# SUNNICA ENERGY FARM

EN010106

8.63 Applicant's Response to Other Parties' Deadline 2, 3 and 3A  
Submissions

<b>Planning Inspectorate Scheme Reference</b>	EN010106
<b>Application Document Reference</b>	EN010106/APP/8.63
<b>Author</b>	Sunnica Energy Farm Project Team

-  Sunnica - Proposed Boundary Scheme - 3.582ha (8.85ac)
-  Within Mitcham's Ownership - CB426716 & CB426650

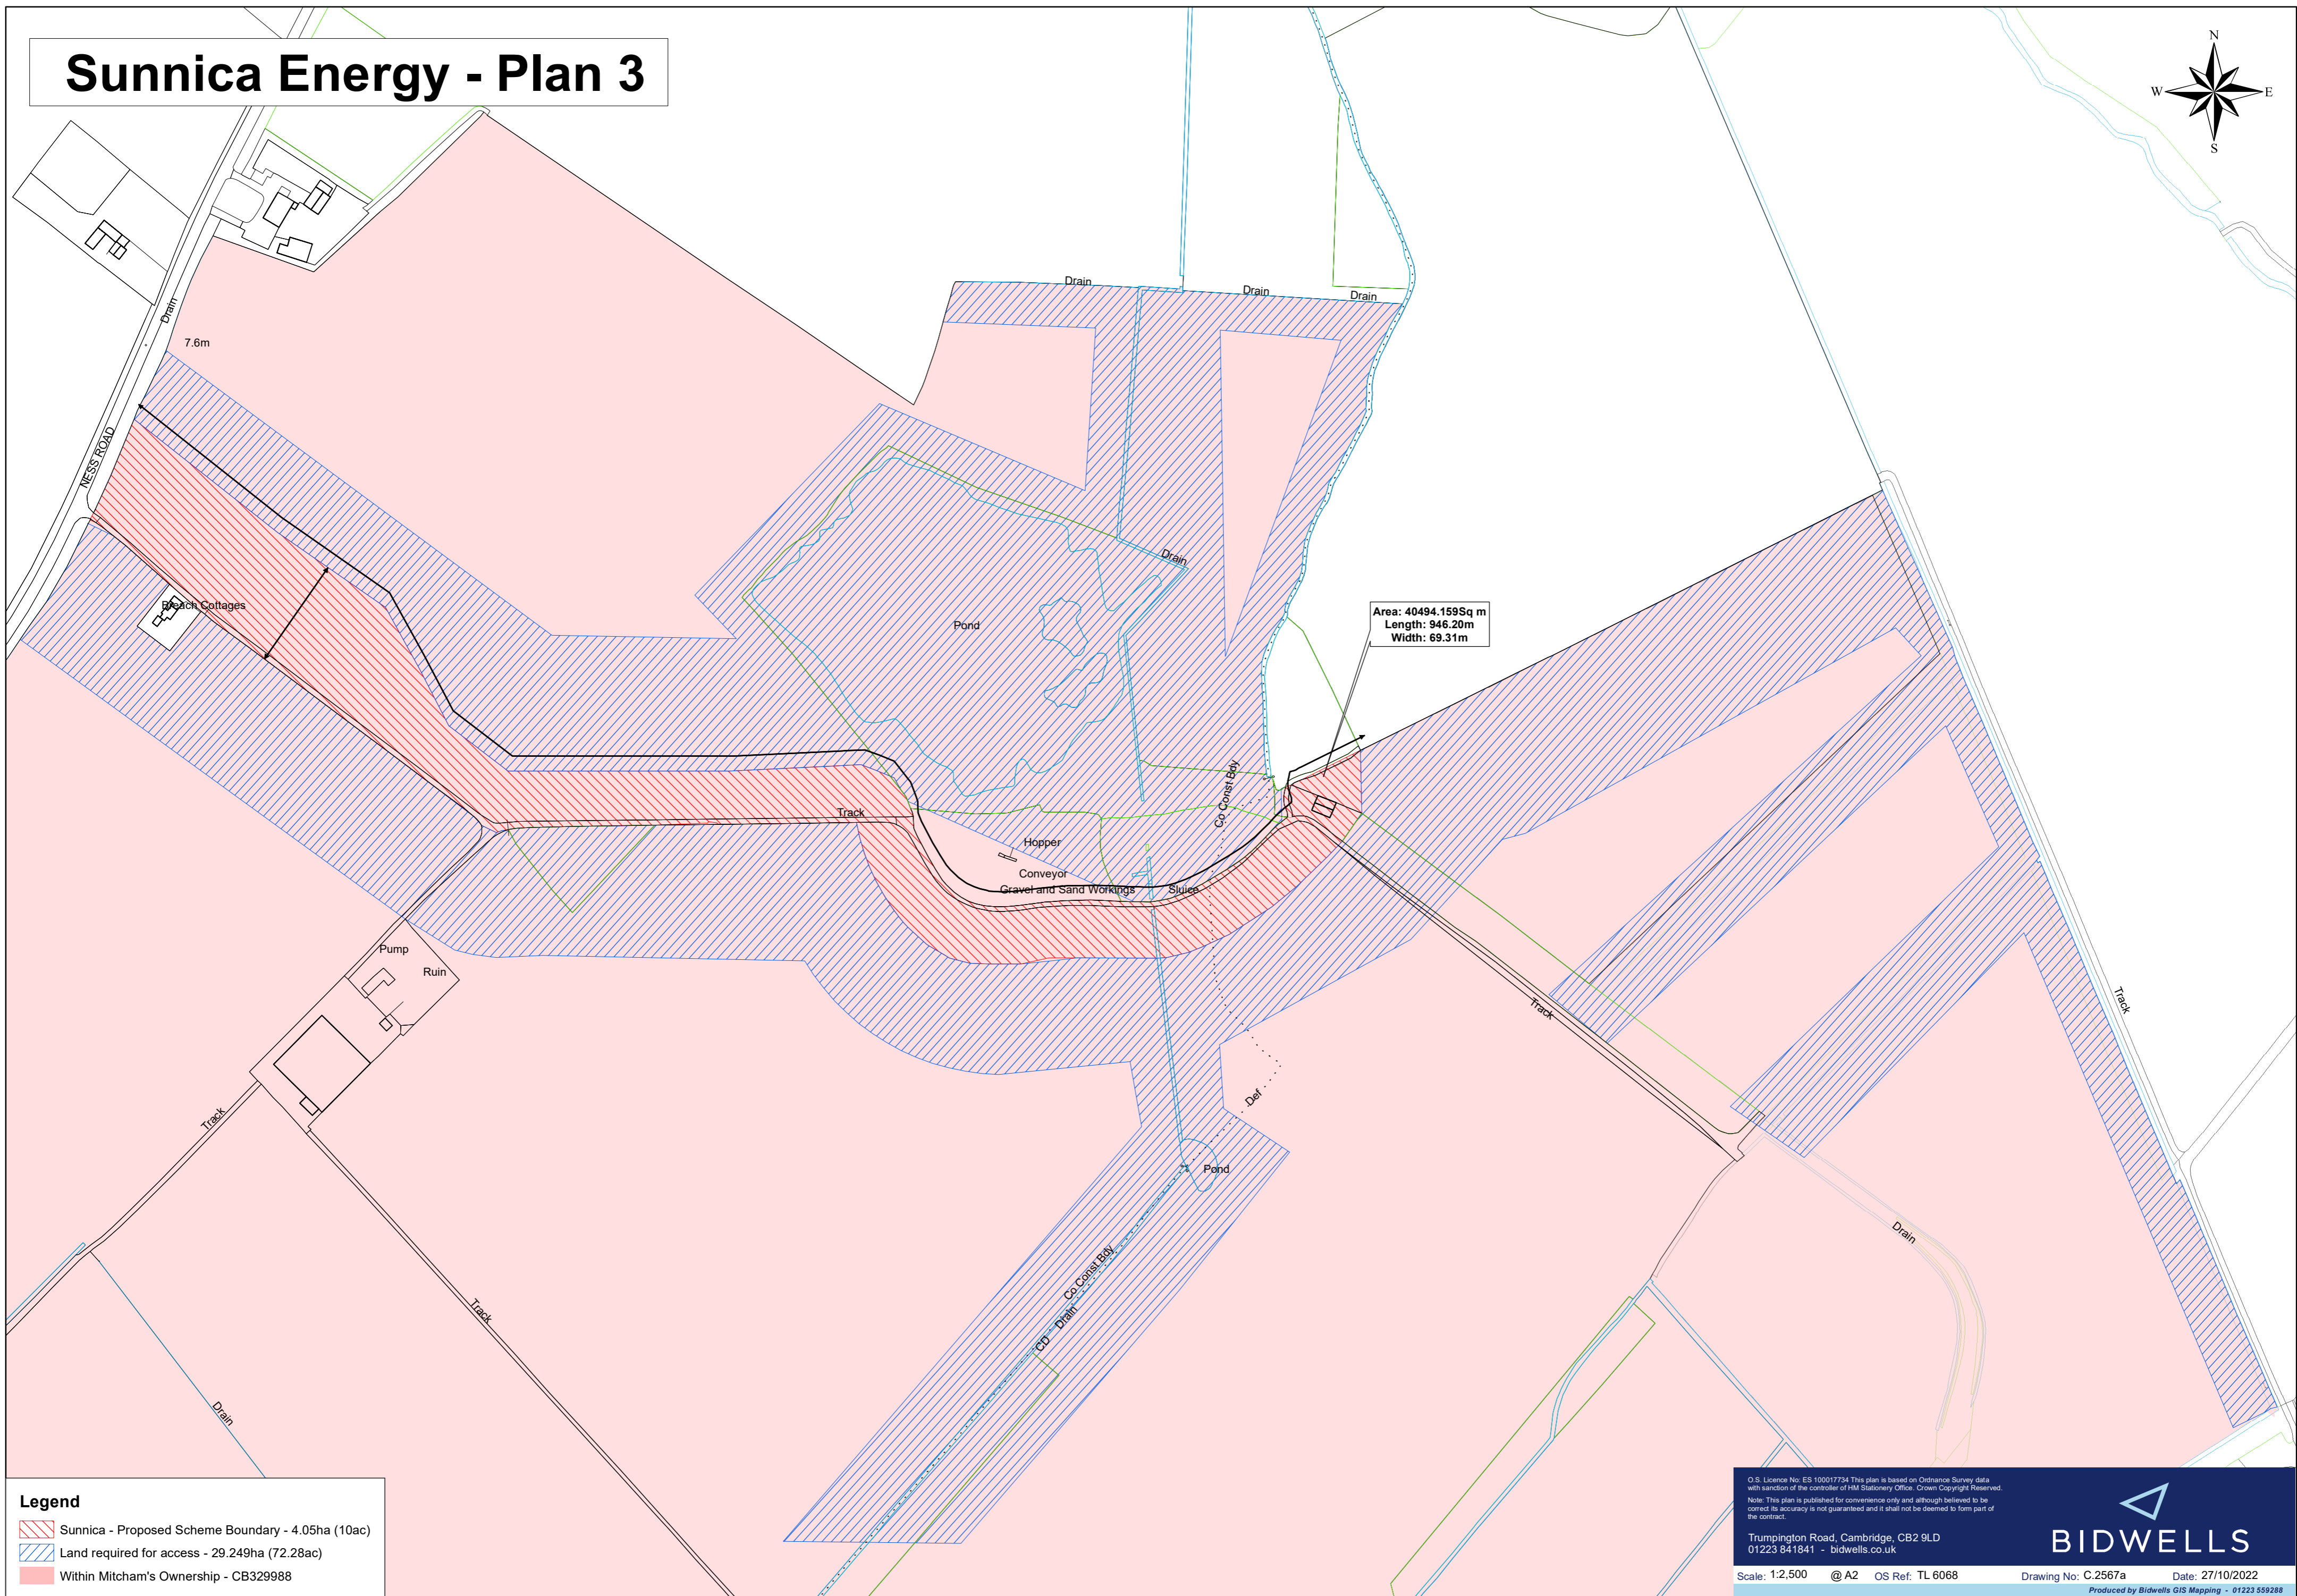
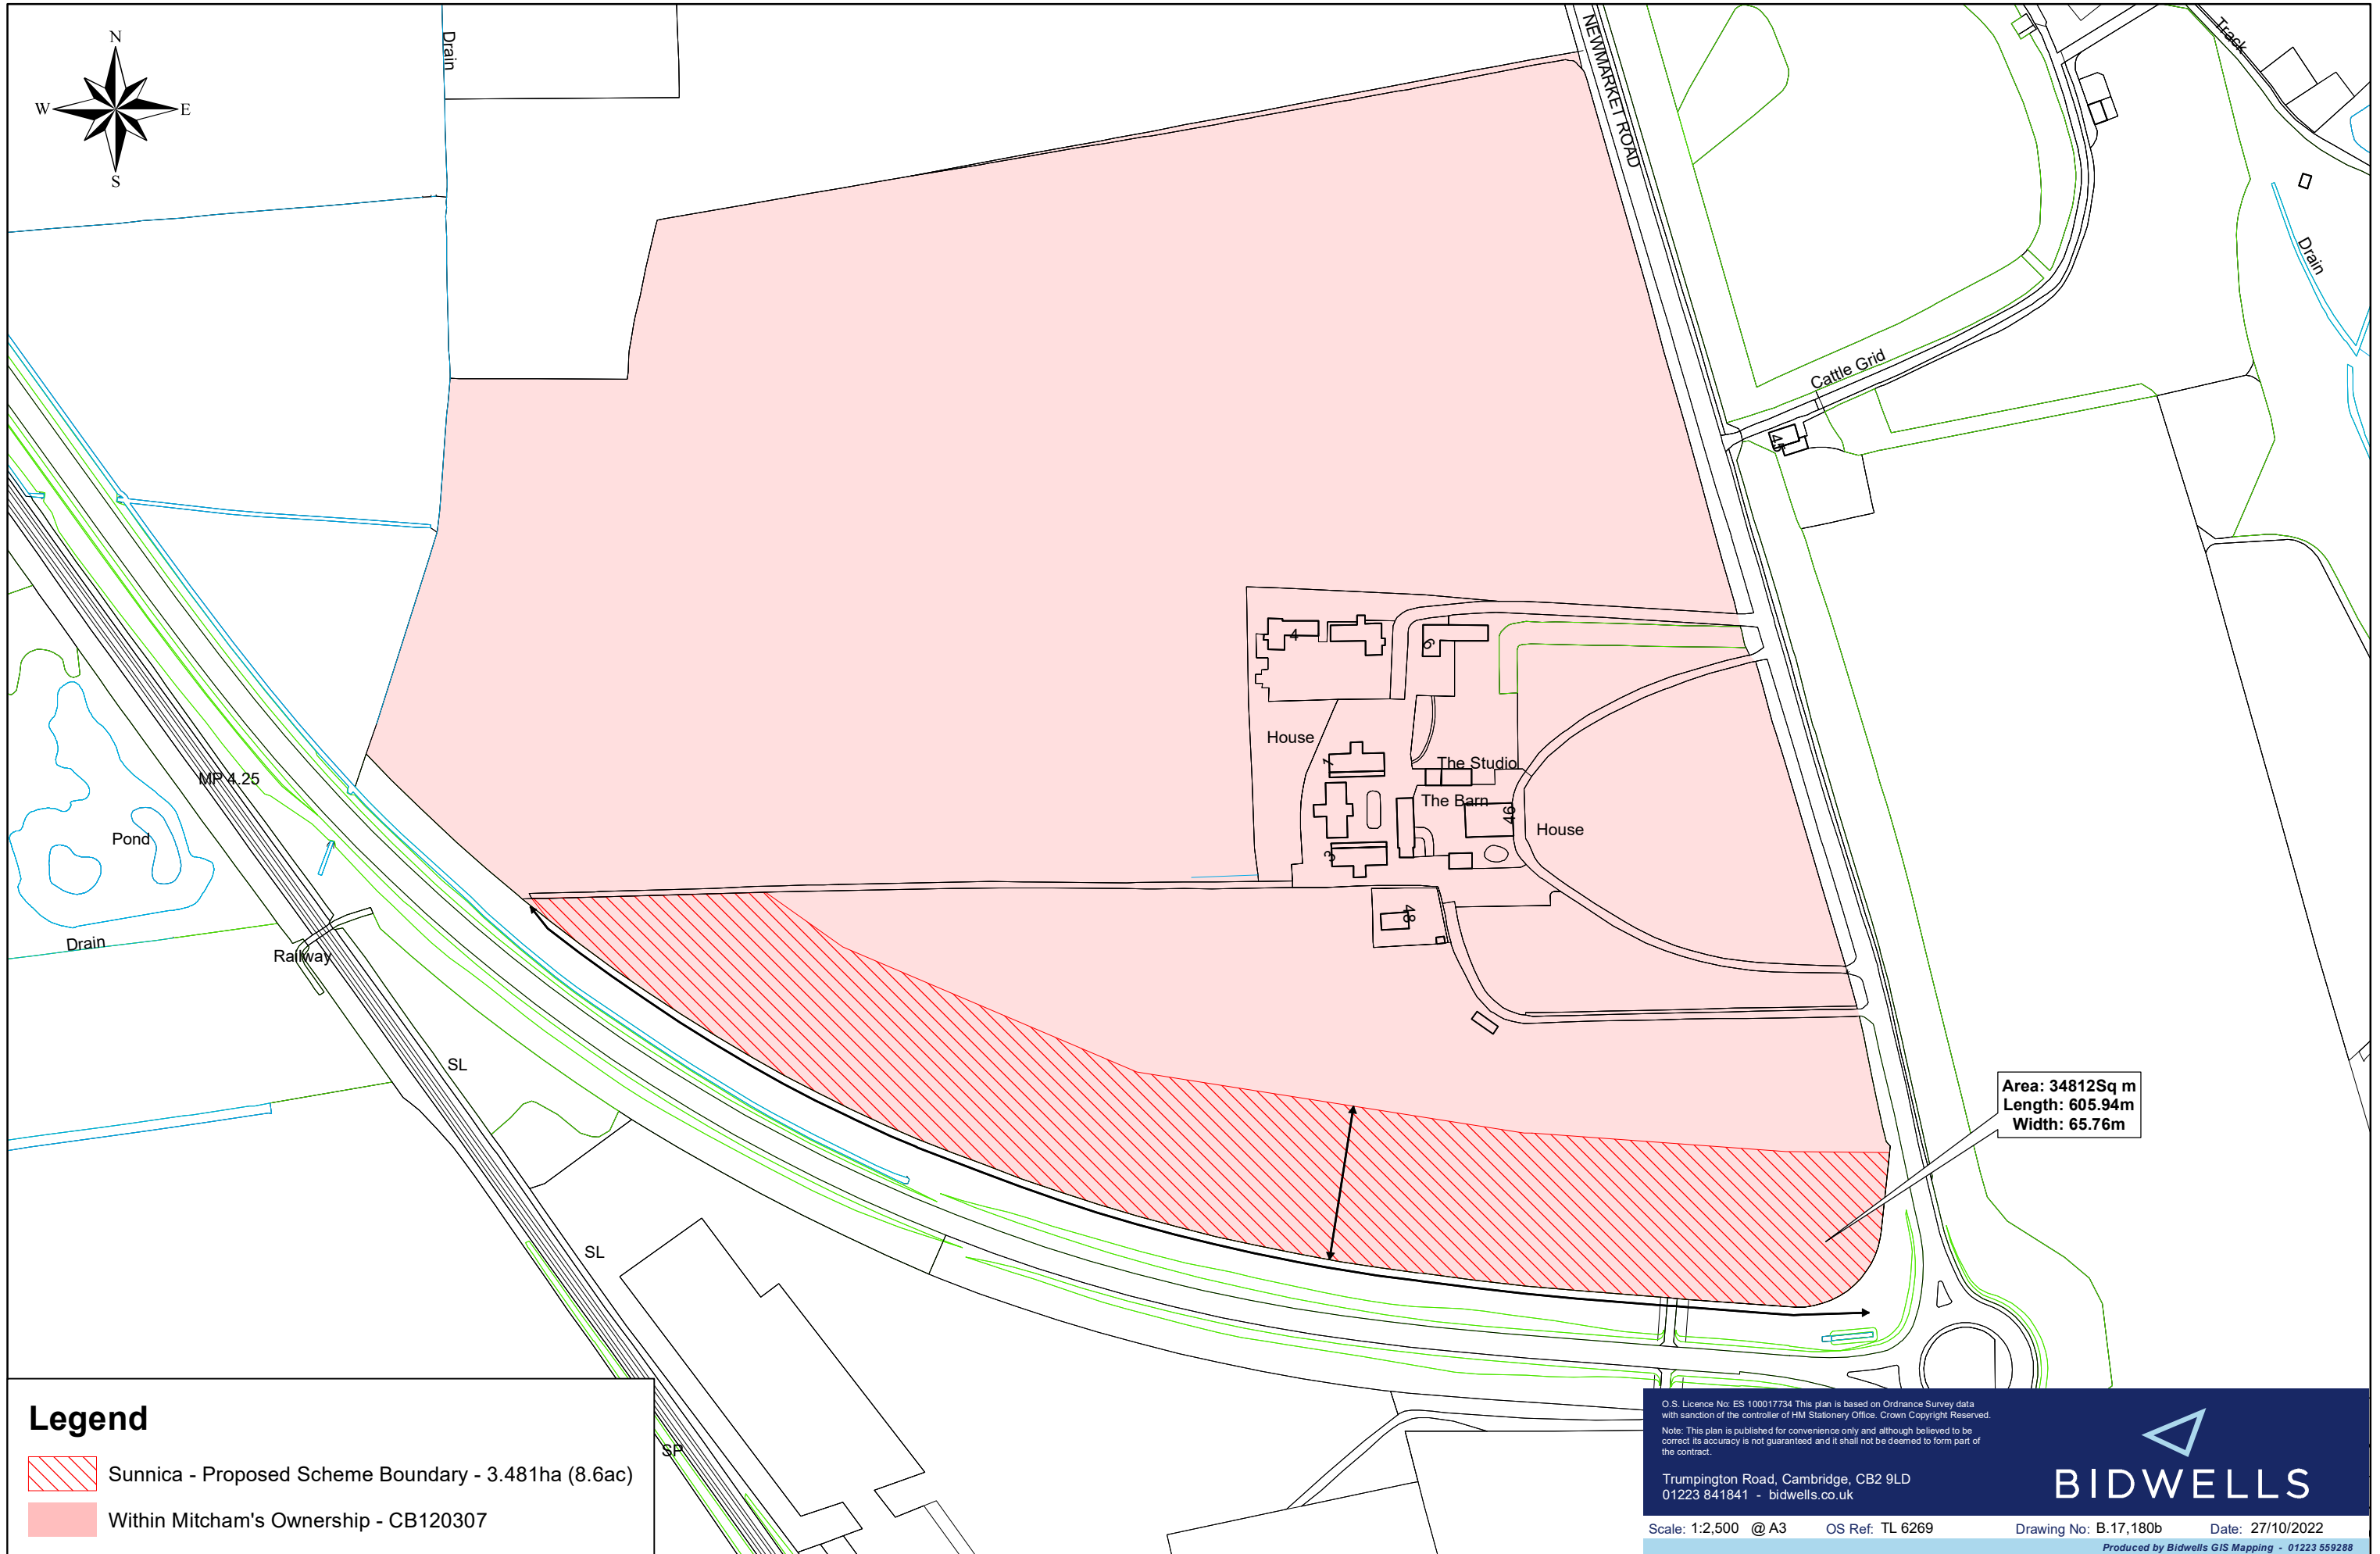
Party name	Theme	Summary of issue raised	Applicant's response		
	Area of Rights Acquired	<p>The discrepancy between the area Sunnica require for an easement, and the land they are trying to acquire powers over, must be resolved.</p> <p>A particular area of concern for the Mitcham family is Fordham House, where the proposed easement is 55m wide. Not only is this excessive, but on a review by our mapping team, it would appear the plans included within the DCO are actually over 65m wide (Appendix 3).</p> <p>Bidwells are involved in the North Sea wind farm cables, acting for impacted landowners. These cables carry 1.4GW of energy. Easements of maximum 20m are being agreed. It is hard to understand why Sunnica require such wide areas.</p> <p>The Mitcham family is content with the principle of a 10m wide easement and a reasonable working area around this, as appropriate for the maximum 132kV cable. However, the significant areas enclosed within the scheme boundary and the discrepancy between areas actually needed versus included is not reasonable.</p>	<p>Appendix A of the Statement of Reasons explains the requirements for additional widths in the land where rights are being acquired on the cable corridor. The land requirements on the Land Plans have been drawn up in line with the explanation provided in that Appendix and the consequential limits of deviation shown on the Works Plans. It is not intended that the final easement itself would be of a width of 55m, but powers are required over that area to deal with the constraints on the Mitcham Family land. Constraints affecting the Mitcham Family plots are set out below:</p>

<b>Plot</b>	<b>RLB Width</b>	<b>Rationale</b>
			19-03	50m	<p>A working width of up to 50m is required for constrained land. The additional width, beyond the 30m identified for unconstrained land is required due to a specific constraint or potential combination of constraints that have been identified following survey works that were undertaken. These constraints typically result in challenging engineering works/solutions that fall within one of the following categories:</p> <p>Access Issues: There are sections of the Sunnica route where site access onto the cable route corridor from either the public highway or onto the cable route corridor from internal roads or tracks is extremely limited. This means that plant machinery and materials will need to travel along sections of the cable route corridor in order to reach the work site. As such, a wider construction width is required at these locations to provide lateral separation between transport movements and ongoing excavation and cable laying works. Additional space will also be required for the stockpiling of both materials and spoil.</p> <p>Horizontal Directional Drilling (HDD) Required:</p>

Party name	Theme	Summary of issue raised	Applicant's response		
					<p>A number of sections requiring HDD have been identified during survey works. An increased construction width is required at these locations for reasons that include a. To allow spacing of the bores; b. To allow for the excavation of the launch and receive pits; Sunnica Energy Farm Statement of Reasons Planning Inspectorate Scheme Ref: EN010106 Application Document Ref: EN010106/APP/4.1 Page 76 c. To allow space for the additional heavy plant required; d. To allow space for the materials required at hand (e.g., water tanks, bentonite, duct); or e. To allow for the safe movement and turning of vehicles</p>
			18-18	<20m	<p>Directional drilling will be required in order to cross drainage and field boundaries. There is limited access available across this section of the cable route and in order to accommodate the necessary equipment and materials required it may be necessary to utilise part of this plot for the laying of the cable This will be determined at detailed design</p>

18-10	30m / 100m	<p>Directional drilling will be required in order to cross drainage and field boundaries. There is limited access available across this section of the cable route and in order to accommodate the necessary equipment and materials required, a wider cable route corridor width of circa 100m is necessary.</p>
			18-09	100m	<p>The corridor width has been widened in this location as geophysical survey was incomplete and adequate space is required to allow micro siting of the cable at the detailed design stage. In addition, there are challenges crossing the two gas pipes either side of Ness Road</p>

Party name	Theme	Summary of issue raised	Applicant's response		
			18-01	70m	The geophysical survey identified potential archaeological features within plot 18-01, therefore the cable width is required in order to microsite the cable during detailed design. In addition, there are challenges crossing the two gas pipes either side of Ness Road
			17-03	35m / 70m	The geophysical survey identified potential archaeological features within plot 17-03, adjacent to Plot 18-01, therefore the cable width is required in order to microsite the cable during detailed design. Narrow to follow the track as far as possible and minimise the impact on the extent of the proposed Breach Solar Farm. There are challenges crossing the two gas pipes either side of Ness Road
			16-14	60m	<p>Network Rail crossing and Specific pinch point</p> <p>This section of the route is subject to a number of constraints and engineering challenges.</p> <ul style="list-style-type: none"> <li>i. Directional drilling will be required to pass beneath the A142 and the adjacent railway line;</li> <li>ii. There is limited access for labour, plant and materials throughout this section; Up to circa 100m wide Sunnica Energy Farm Statement of Reasons Planning Inspectorate Scheme Ref: EN010106 Application Document Ref: EN010106/APP/4.1 Page 77</li> <li>iii. A requirement to cross an existing high pressure gas main running approximately north – south in the vicinity of Newmarket Road;</li> </ul>

Party name	Theme	Summary of issue raised	Applicant's response	
				<ul style="list-style-type: none"> <li>iv. There are significant areas of potential archaeological interest located on each side of the A142 / rail crossing;</li> <li>v. Significant alignment changes are required in both plan and section. The combination of constraints across this section means that an increased corridor width of circa 100m will need to be retained in order to complete the works</li> </ul>
			<p>Regarding the land at Fordham House this is an area where HDD will be required in order to route the cable underneath the adjoining A142 and the railway. An increased construction width is required for reasons that include allowing the spacing of the bores, to allow for excavation of the launch and receive pits, to allow space for the additional heavy plant required, to allow space for the materials required at hand, to allow for the safe movement and turning of vehicles.</p> <p>The exact width of permanent easement required is not yet known in this location as detailed design has not taken place.</p>
